LANSDOWN HOUSE
WALBERTON
ARUNDEL
WEST SUSSEX
BN18 OPG

16 June 2019

**Application WA/44/19/PL. Walberton Baptist Church The Street
Walberton BN18 OPG. Temporary permission (maximum 12 months) for
a single storey timber framed WC & lobby extension**

PROPOSED ELEVATIONS

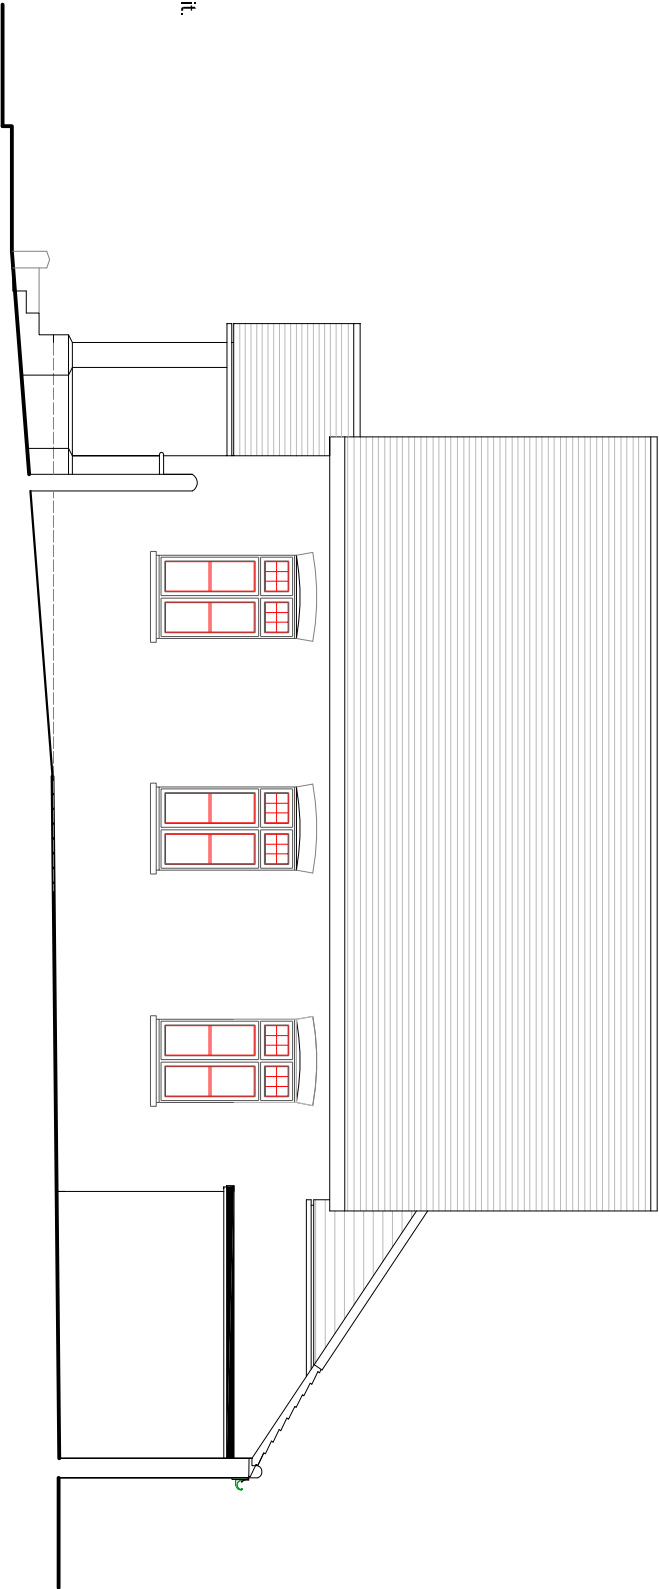
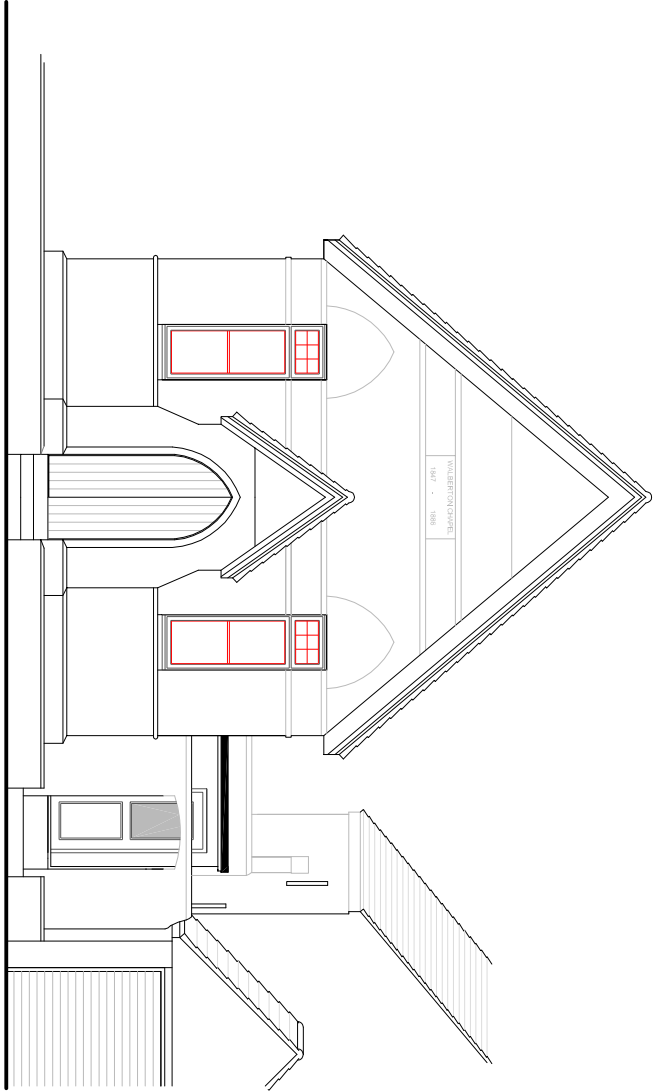
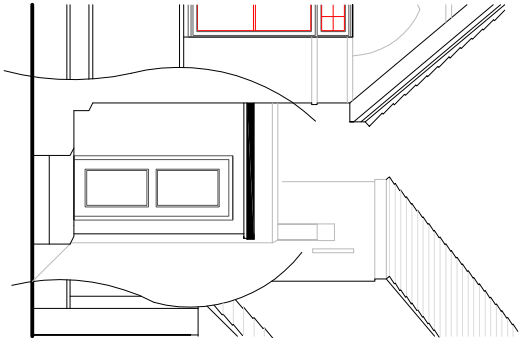
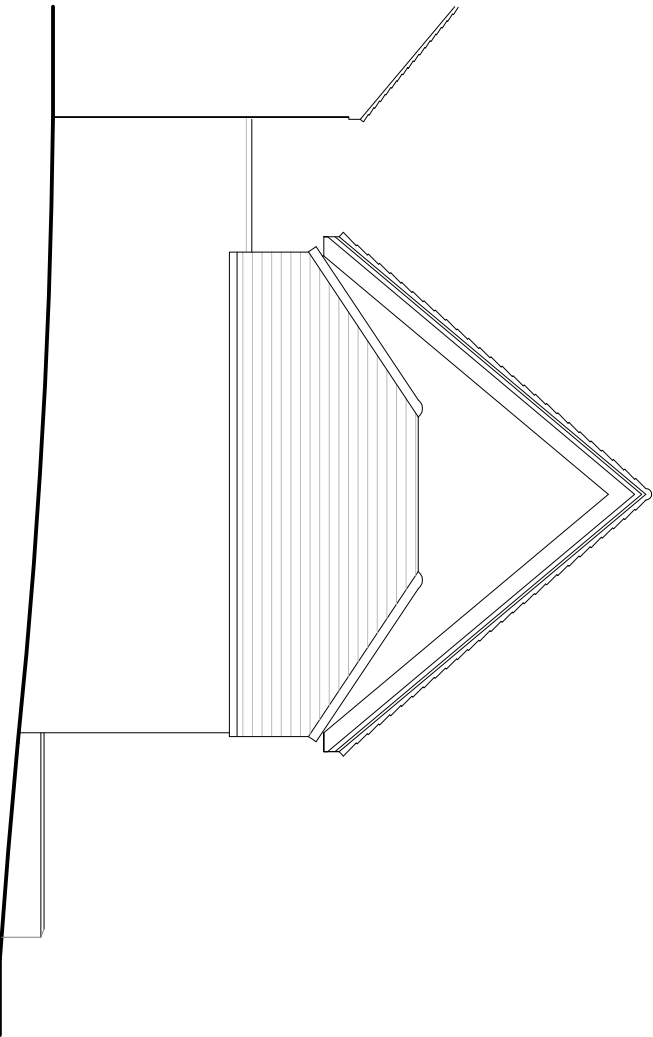
The extension, which already exists, comprises a poorly designed, utilitarian and unsightly timber structure with cedar brown walls, white UPVC openings and flat felt roof. The extension is attached to the side of the Baptist Church and projects close to the side wall of Lansdown House. Both of these properties are described as being Structures of Special Character in Schedule 5 of Walberton Neighbourhood Development Plan (WNDP). They make a significant contribution to the character, appearance and significance of the Walberton Conservation Area.

The extension is currently hidden behind the existing front wall and gate of the site. The view from The Street was blocked off during the construction of the extension. The gate will however be removed to provide access to the front entrance to the extension. As a consequence, the extension will be clearly visible from the street scene, where it will have a harmful and degrading impact on the street scene, the setting of the Baptist Church and Lansdown House and the character, appearance and significance of the Walberton Conservation Area. One only has to read the comments made by the Council's heritage officer in relation to other proposals along The Street to appreciate this.

Given the totally insensitive and unsightly design and appearance of the extension it clearly fails to comply with all of the above policies and Section 72 of the LBCA Act. To approve the proposal would not only be totally contrary to policy and practice at all levels, it would set a precedent for degrading and substandard additions to other locally important public and private buildings within the Walberton Conservation Areas and elsewhere in the District. As reinforced in planning guidance planning decisions need to be consistent to be credible.

PROPOSED GROUND FLOOR PLAN

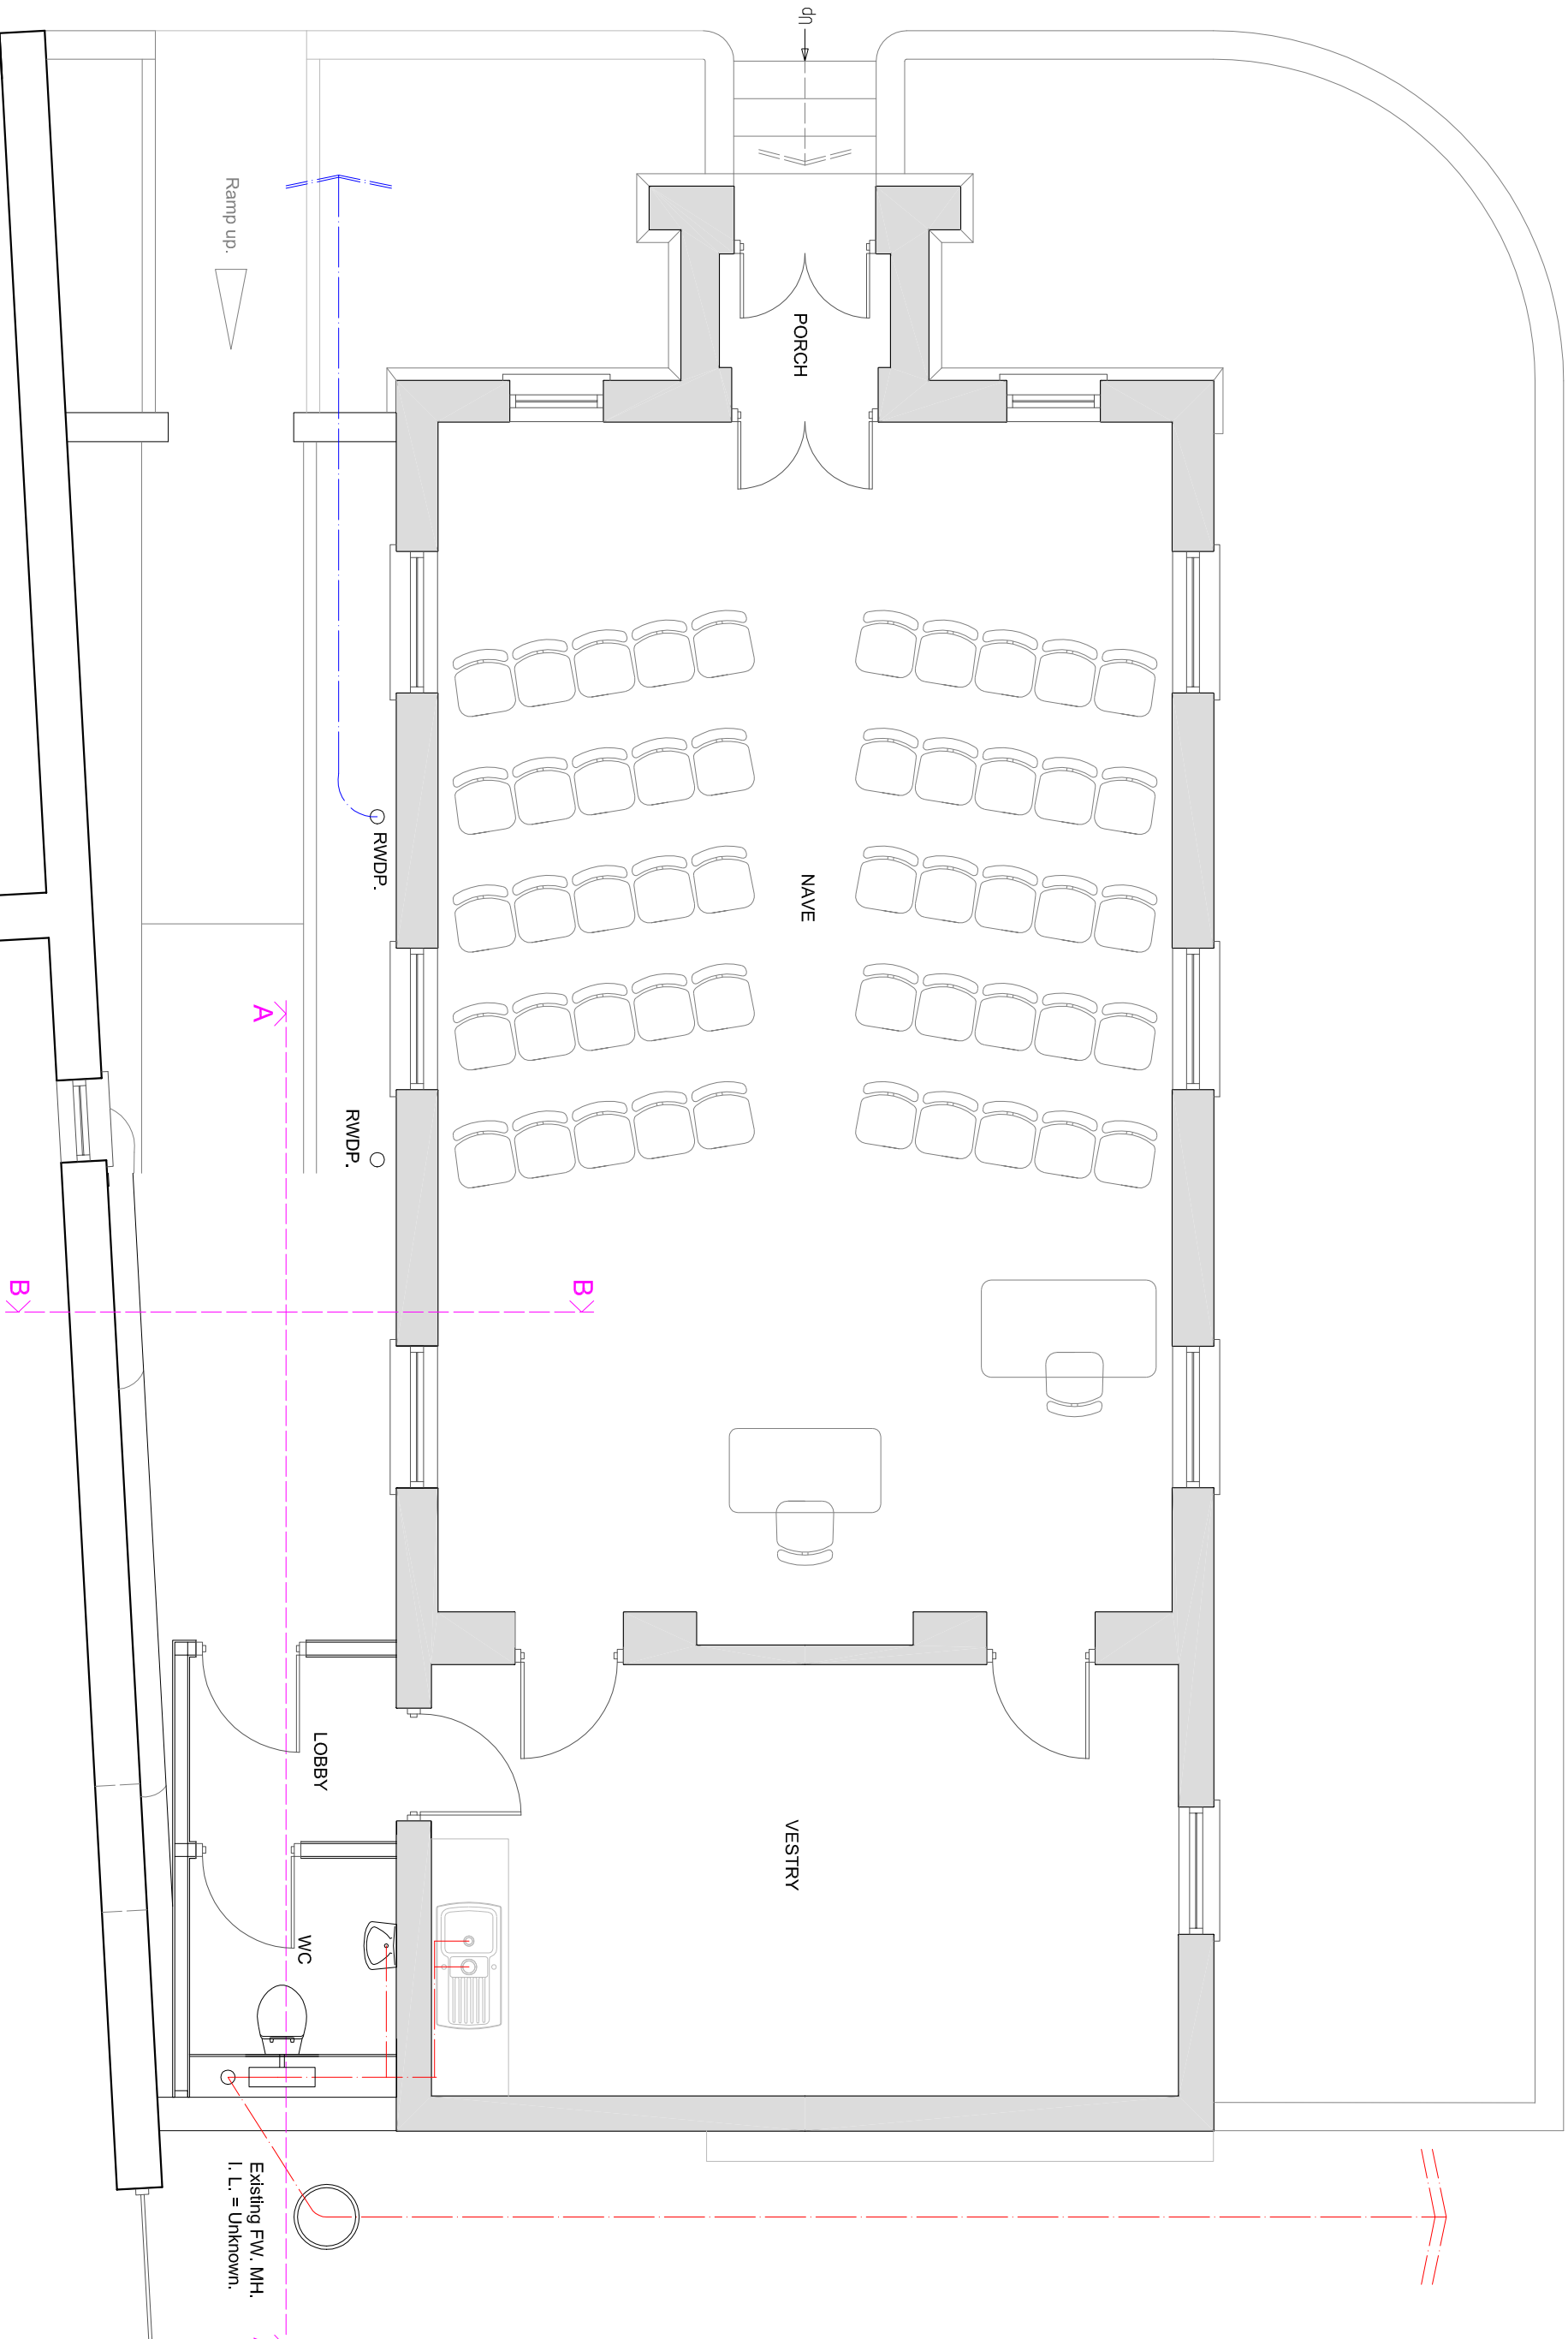
To make matters worse a small and awkward gap has been left between the side wall of the extension and the historic side wall to Lansdown House. This is inaccessible; it will result in problems of damp and the accumulation of debris and rubbish with all of which it will be impossible to deal adequately. Visually this will add to the degrading appearance of the extension and could well have a materially adverse impact on the condition of the side wall to Lansdown House.

In addition, it has not been demonstrated that the extension will be adequately drained both in relation to surface and foul drainage. Without suitable drainage
